CITY OF ALBUQUERQUE

January 24, 2022

**RE: 801 Vista Faisan Trl
801 Vista Faisan Trl
Grading and Drainage Plan
Engineer's Stamp Date: 10/8/2021
Hydrology File: F14D057B**

Based upon the information provided in your submittal received 01/06/2022, the Grading & Drainage Plan **is not** approved for Building Permit. The following comments need to be addressed for approval of the above referenced project:

ENGINEER'S SEAL	801 VISTA FAISAN	DRAWN BY WCVJ
	GRADING AND DRAINAGE PLAN	DATE 2-09-22
		20220011-LAYOUT-2-09-22
2/10/22	 <i>Rio Grande Engineering</i> 1606 CENTRAL AVENUE SE SUITE 201 ALBUQUERQUE, NM 87106 (505) 872-0889	SHEET # —
DAVID SOULE P.E. #14522		JOB # 20220011

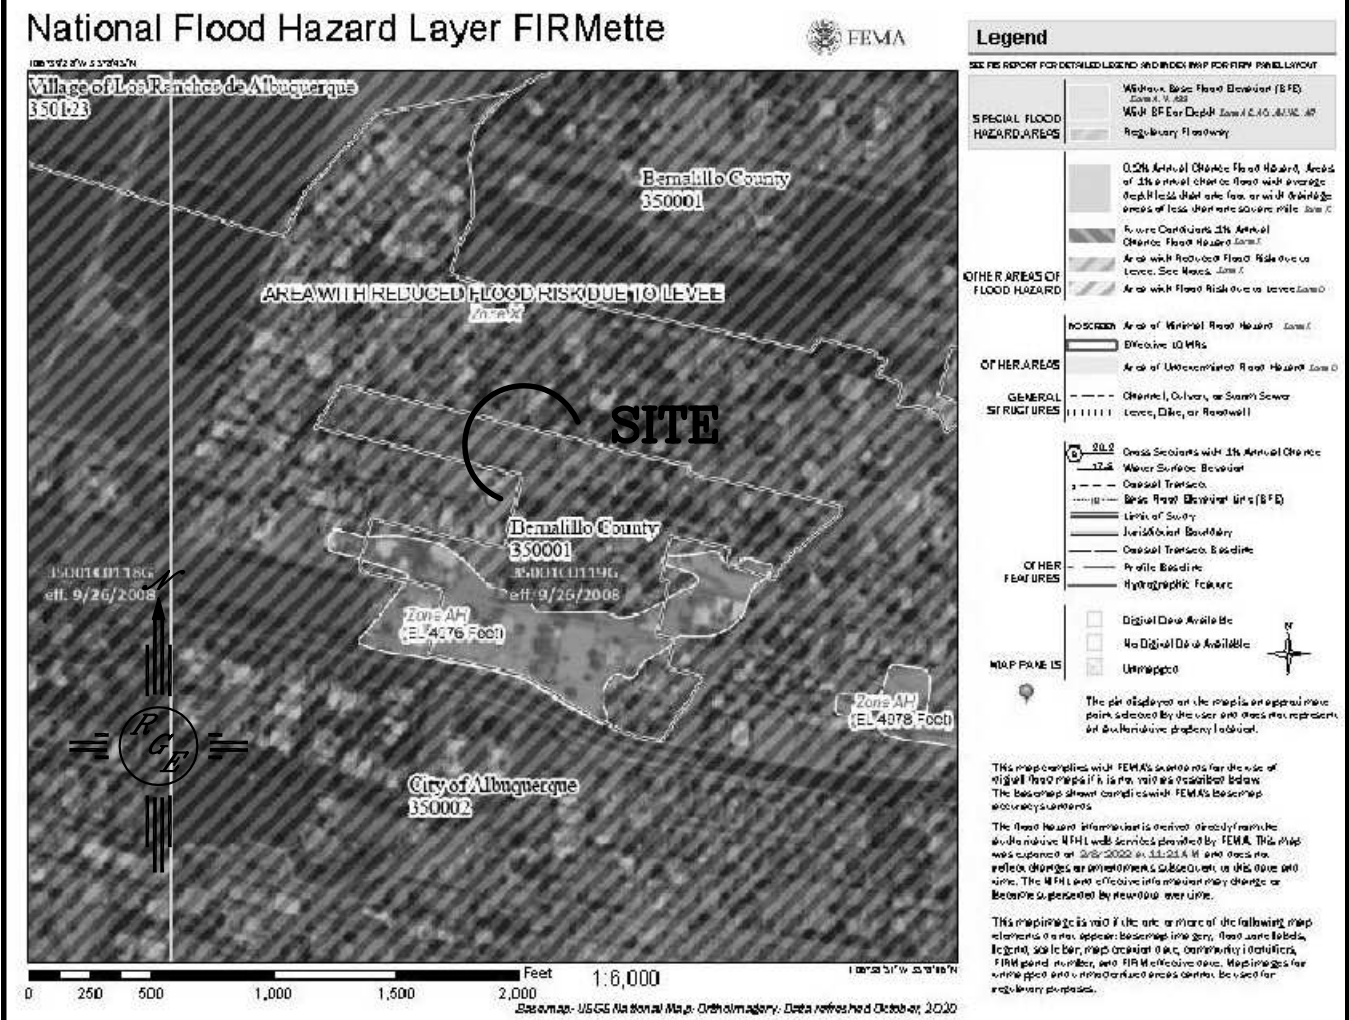
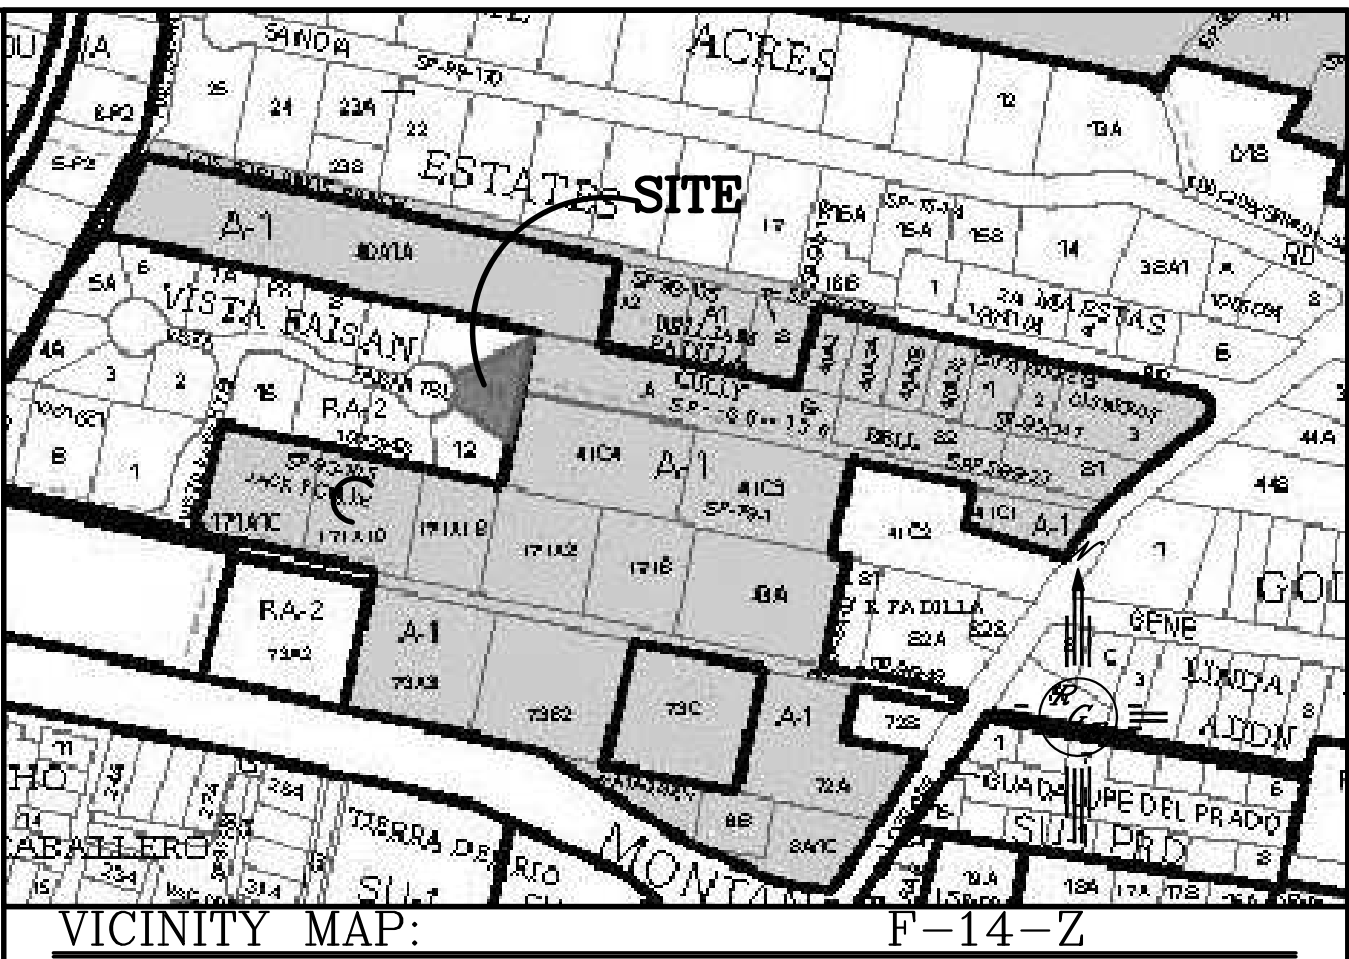
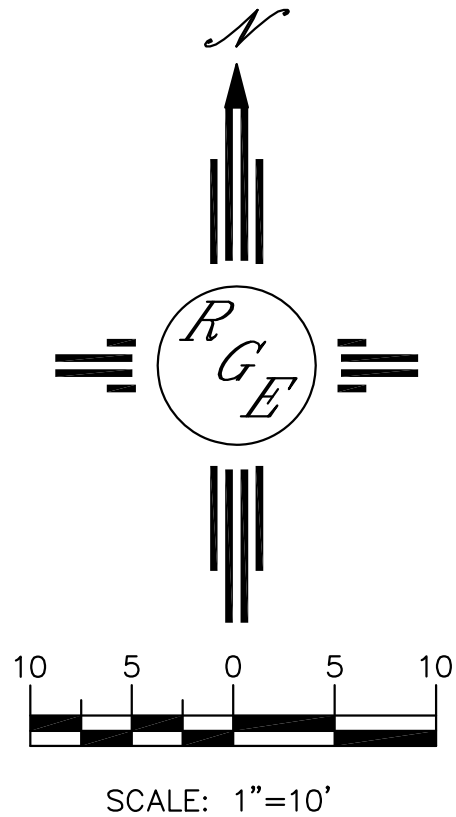
1. Please fill out the DTIS form. The one submitted is blank and needs to provide information for the project and approvals being requested.
2. Please provide existing elevations and survey information.

3. This site needs to follow the existing Grading and Drainage plan F14D057 to show what is retained on-site and what will drain to the existing retention pond. (See attached)

- a. This site delineates what is allowed but needs to be shown how this will be managed. How will the home drain? All roof drainage to the retention pond?

- b. Provide grades and contours (existing/proposed) showing how this will work.
 - c. Note what the allowable discharge flow is per existing plan as well as volume to be retained. Include information from existing plan as historical information and how the site is being developed now. Show how the new plan meets the existing/historical plan.

4. Please provide calculations per DPM Chapter 6.
5. Please provide land treatments per DPM Chapter 6 to include acreage for each.
 - a. Clearly note impervious area vs. other land treatments.

6. Please clearly label swale vs. pond.
7. Please clearly label walls between properties if existing. If not, please clearly show how this lot will not drain into other lots nor receive flow from other lots.

8. Is the site already rough graded? Please provide pictures showing existing grade to determine if pad certification will be required prior to building permit approval.

- a. Based on existing aerial view it appears it is rough graded.
9. Please include project benchmark and datum.

10. Please add a note under Grading Notes. "Side slopes need to be stabilized with Native Grass Seed (per City Spec 1012) with Aggregate Mulch or equal (Must satisfy the "Final Stabilization criteria" CGP 2.2.14.b.)".
